Your ref: SSD-79261463
Our ref: DOC26/99369

**Subject: CPHR comments on RTS – Residential development with in-fill affordable housing
- Reid Street and Woodside Avenue, Lindfield (SSD-79261463)**

CPHR comments on RTS – Residential development with in-fill affordable housing - Reid Street and Woodside Avenue, Lindfield (SSD-79261463)

TITLE:
LANDSCAPE PLAN GF

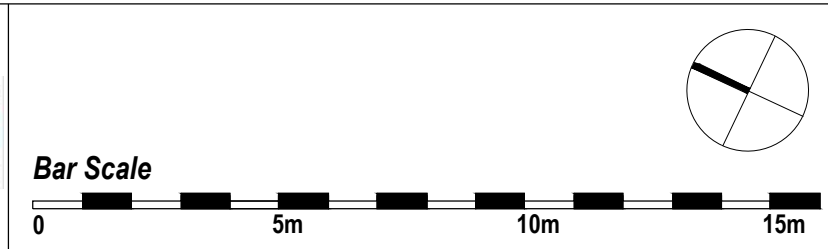
A BDAR waiver determination was issued on 20 February 2026. Notwithstanding, CPHR also recommends that the landscape design is amended to including more species associated with PCT 3136 or 3262 given that they are the local community. For example, replace *Corymbia maculata* with *Corymbia gummifera*.
